DRB Application No.: 03-00566 (SBP)  
Project Name: North Albuquerque Acres  
Agent: Advanced Engineering & Consulting

DRB Application No.: 06DRB-01370 (ASBP)  
Project Name NO ALBUQ. ACRES, TRACT A  
Agent: David Green

**CITY OF ALBUQUERQUE  
 PLANNING DEPARTMENT  
 DEVELOPMENT REVIEW BOARD  
 4/16/03 Comments**

**Subject: North Albuquerque Acres, Lot 29, Block 5, Tract A, Unit B**

**SITE PLAN**

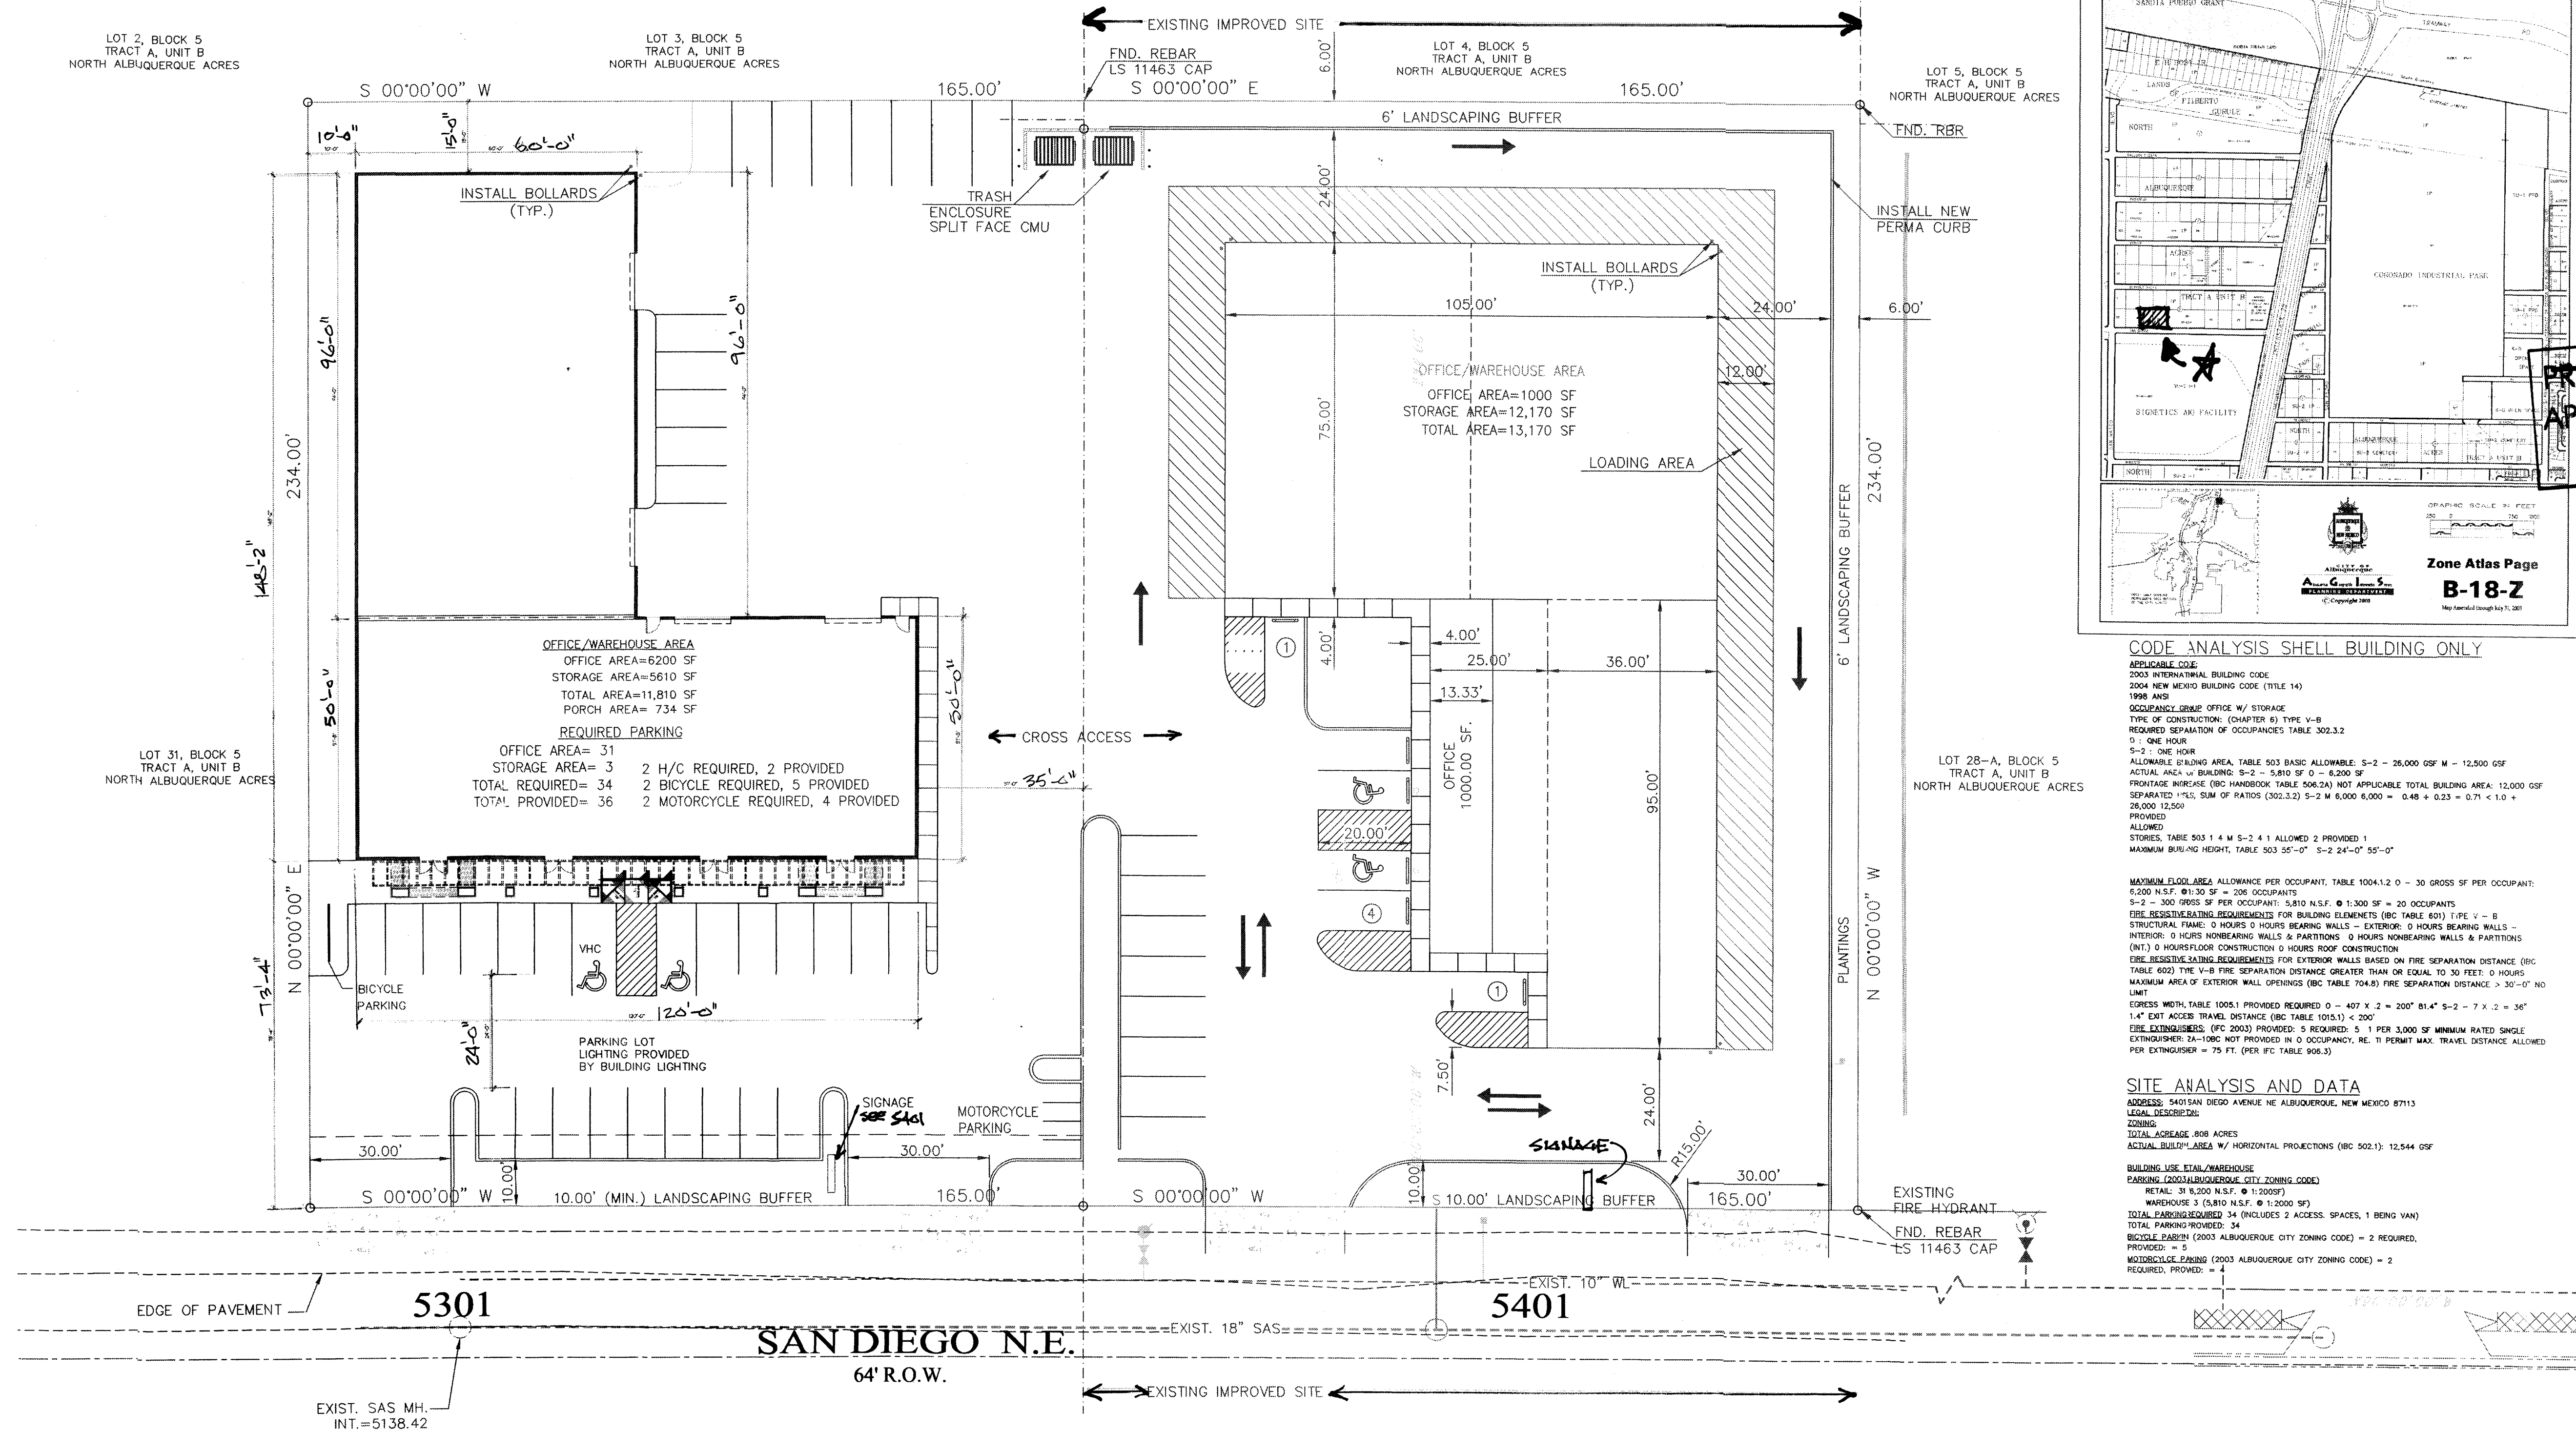
- 1) Are the 4' public roadway easements in place along San Diego?
- 2) Why are there 2 drive pads?
- 3) Where is the sidewalk? (6' is required)
- 4) There is no signature block.
- 5) The parking stalls are not dimensioned.
- 6) Has the cross access document been filed?
- 7) Radii need to meet DPM criteria.
- 8) What is the sidewalk width at the building?
- 9) Is the curb and gutter in place? Is the street a permanent section? (infrastructure is required)

**LOT 29, BLOCK 5, TRACT A, UNIT B, NAA  
 SITE PLAN FOR BUILDING PERMIT**

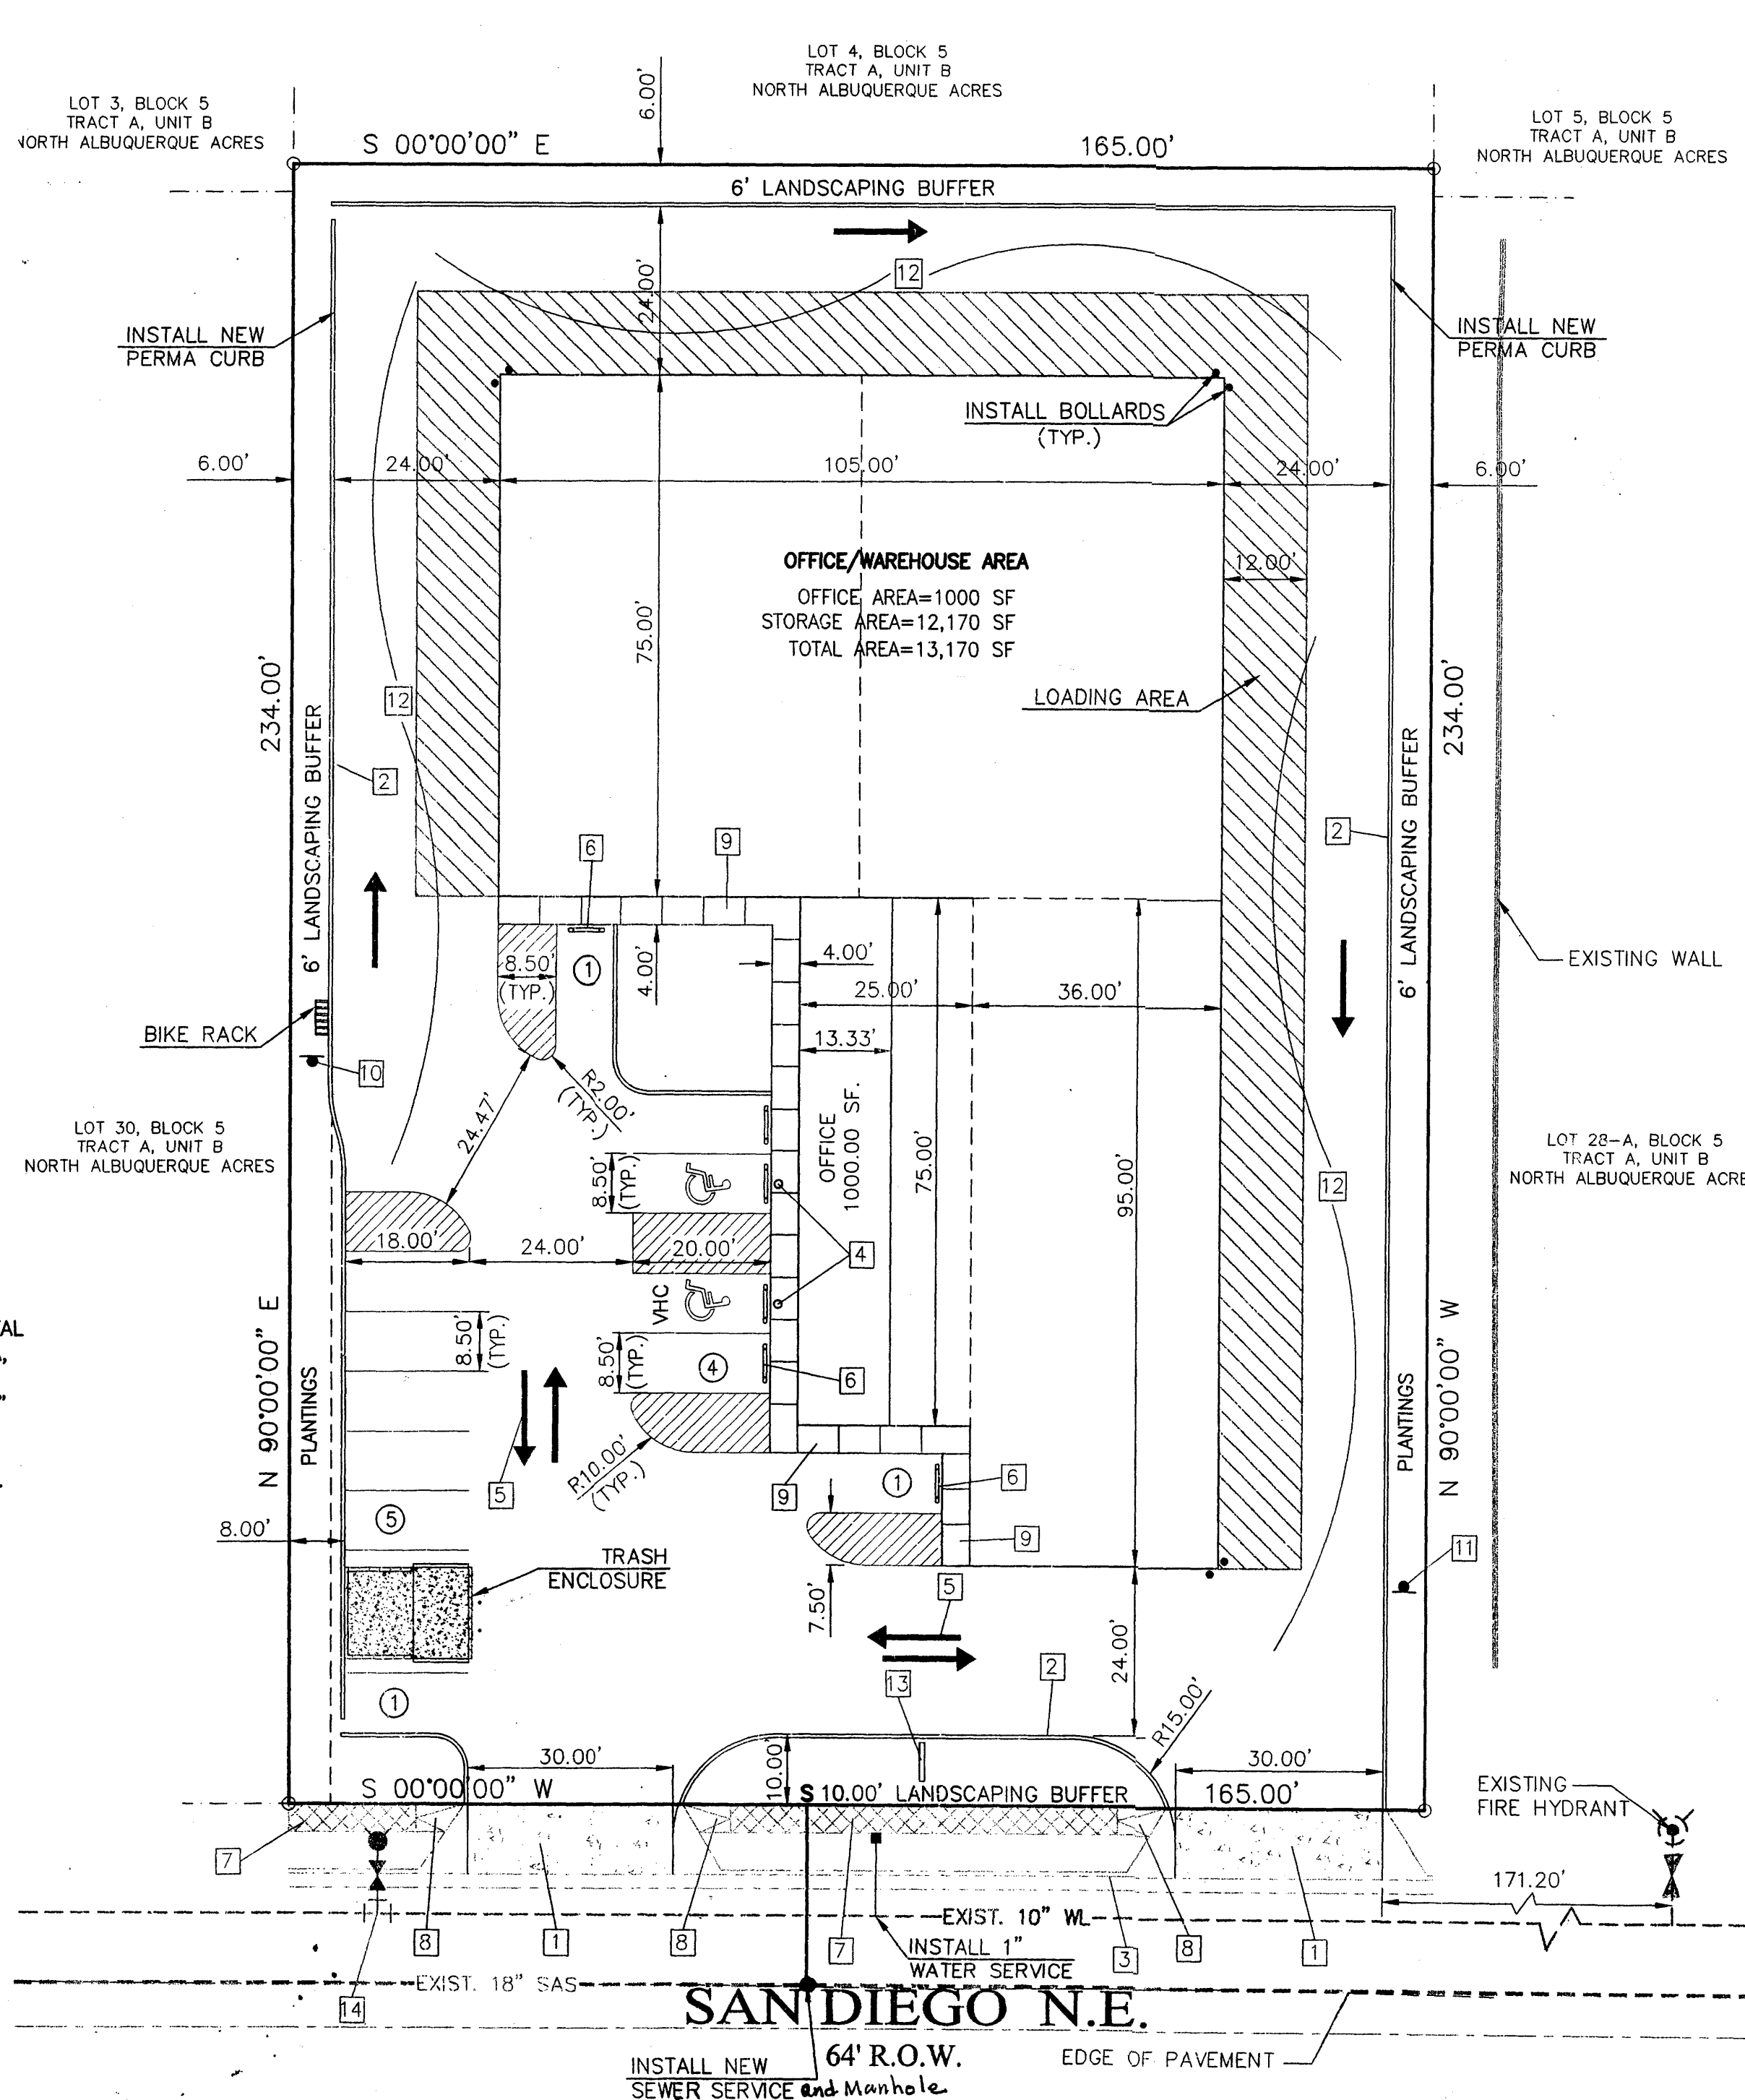
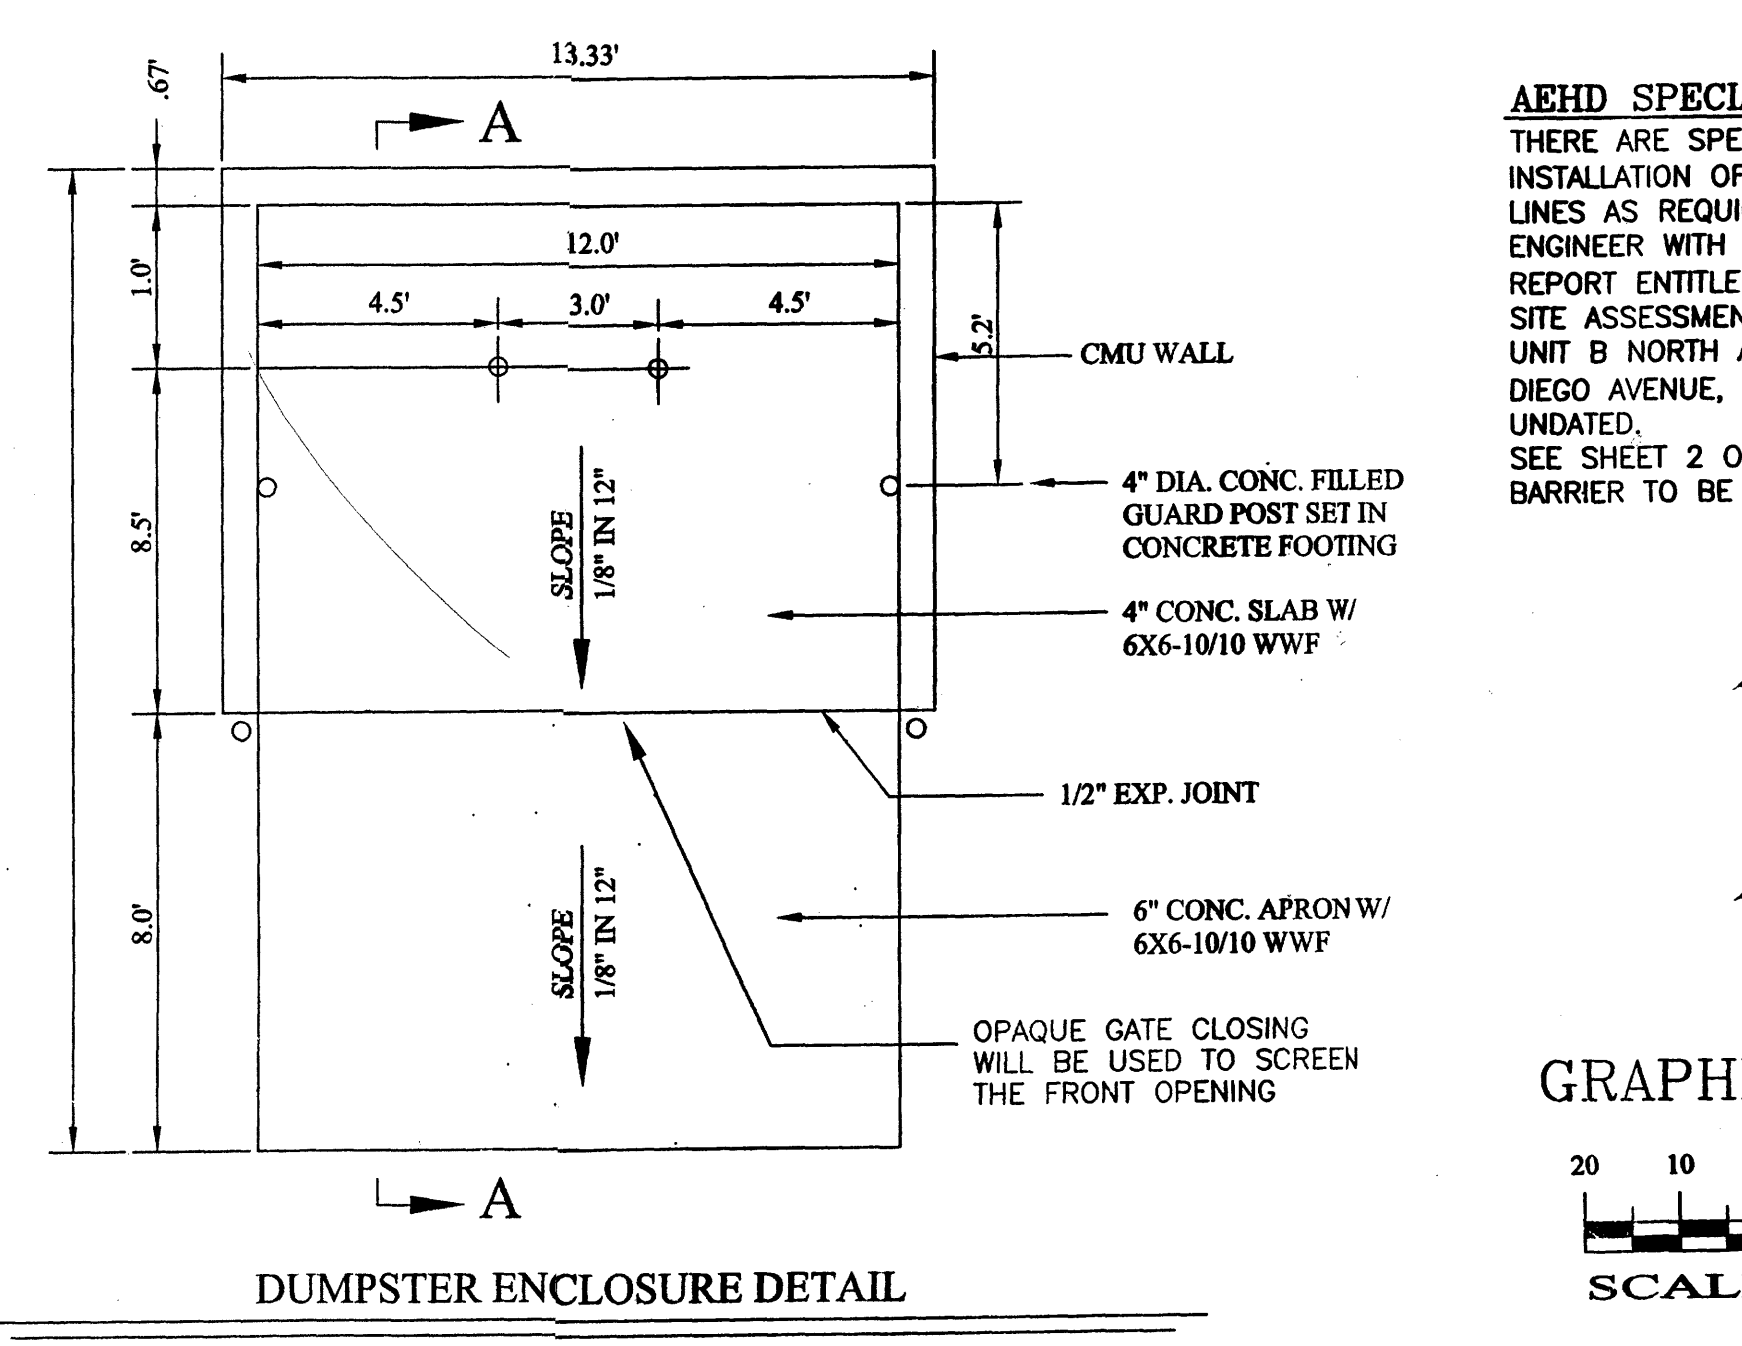
Please get a new signature block from the Front Counter and substitute it for the one used on the site plan submitted for review.

Page 1 identification should state "Site Development Plan for Building Permit" as stated in the application.
